Your Ref: 100471244-001
Our Ref: 21/02959/ADV

Application No: 21/02959/ADV
Proposal: Display of two internally illuminated logo signs, one non-illuminated fascia sign, one internally illuminated projecting sign, ten non-illuminated poster signs and one internally illuminated totem sign

Address: 10 Low Road Auchtermuchty Cupar Fife KY14 7AU

Item 1B - scale 1:20 @ A3

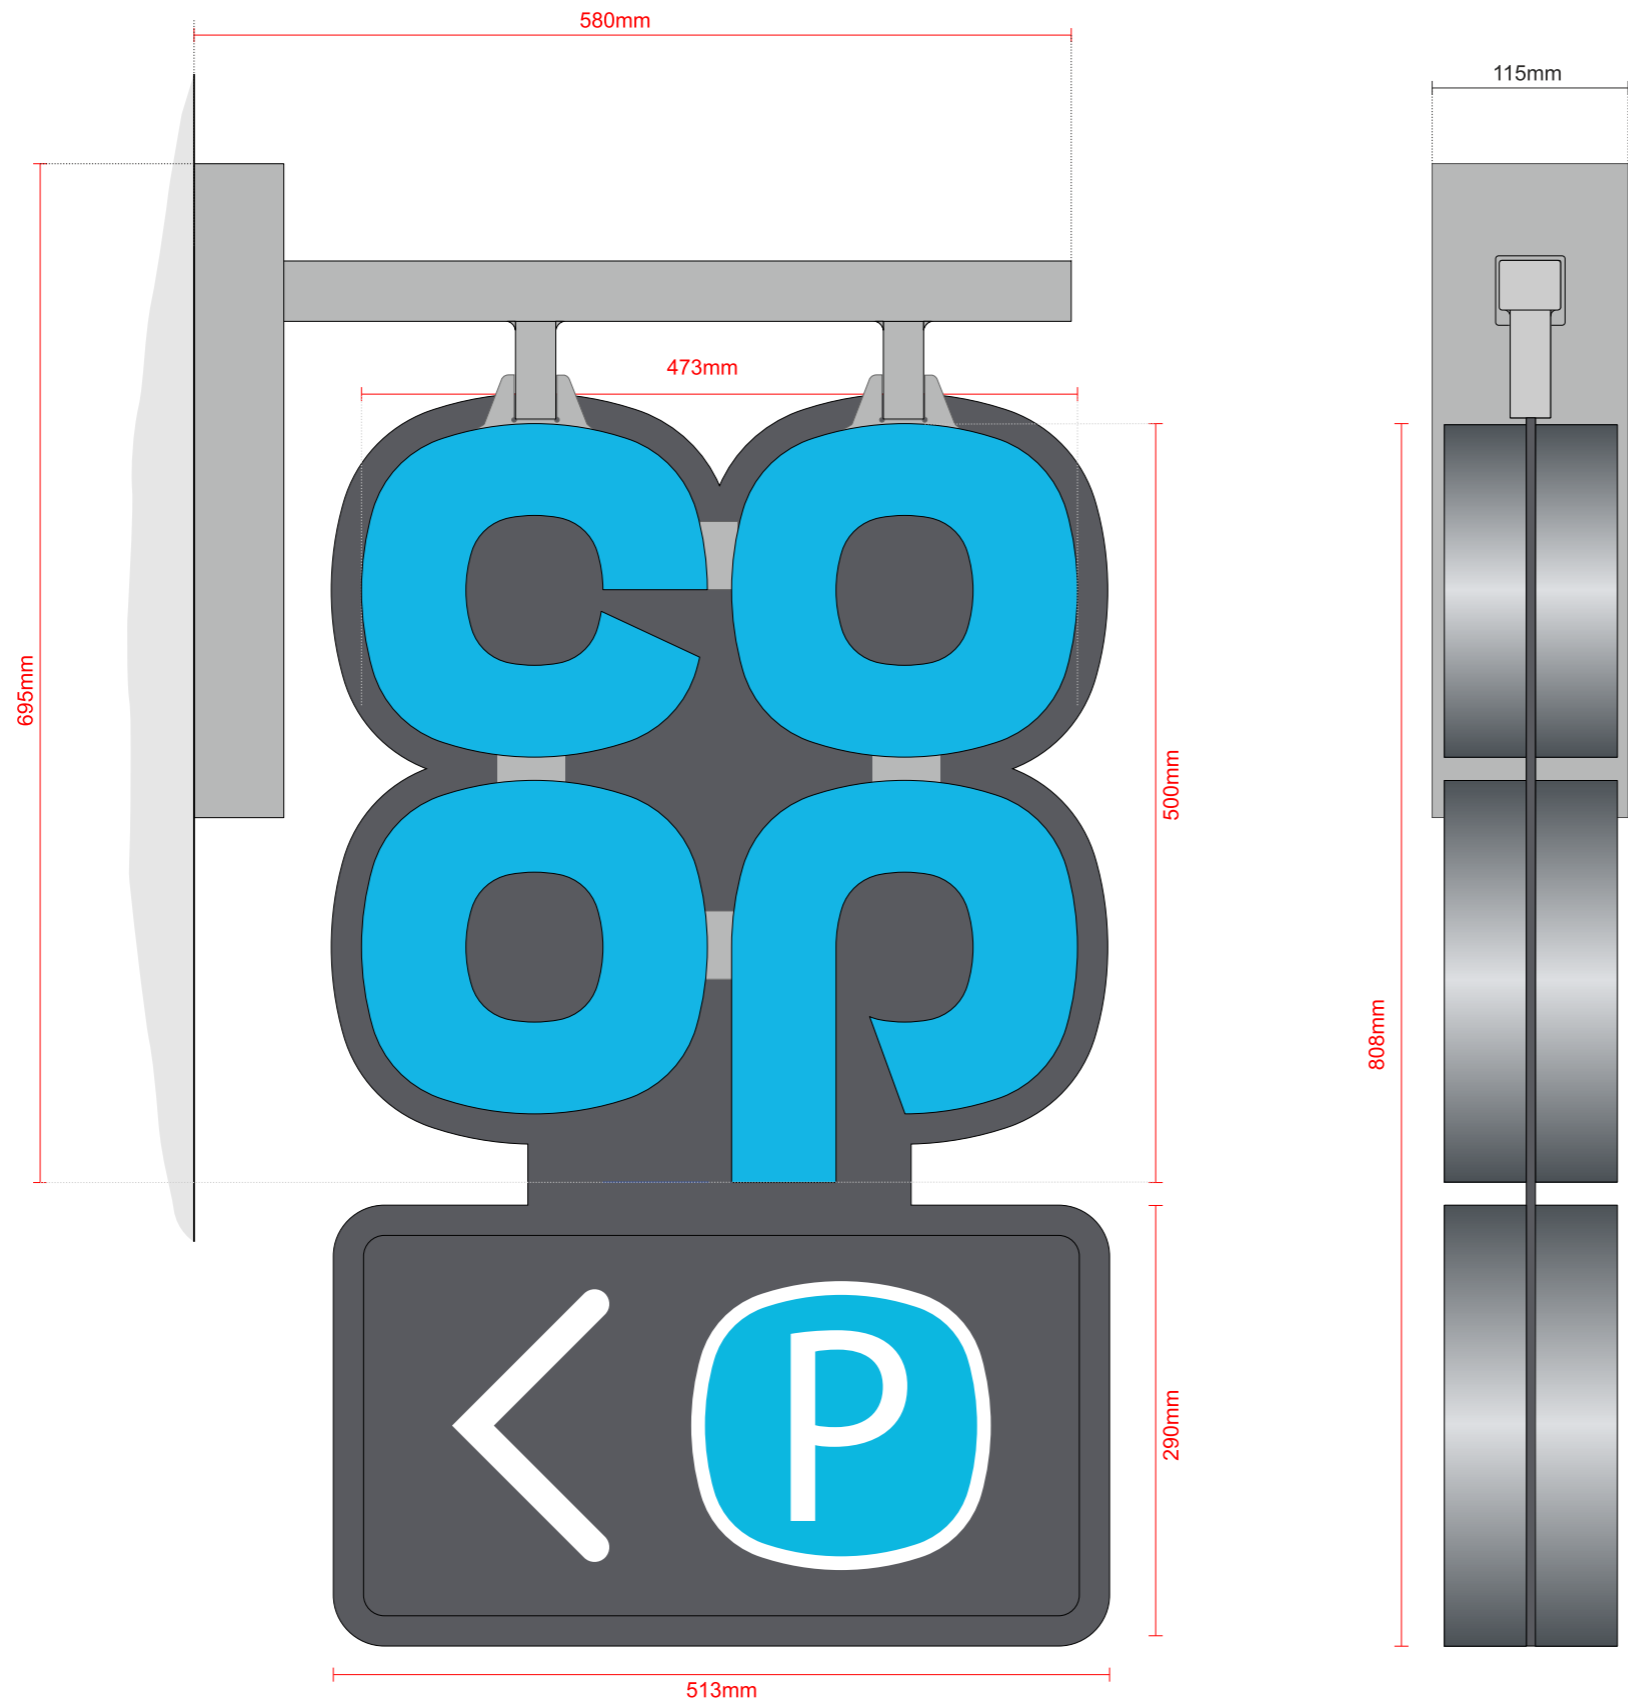
3. You have not submitted detailed plans and elevations at 1:50 or 1:20 for sign 1B. Please submit such plans demonstrating its size, method of construction, type of illumination (if relevant), colour and materials.
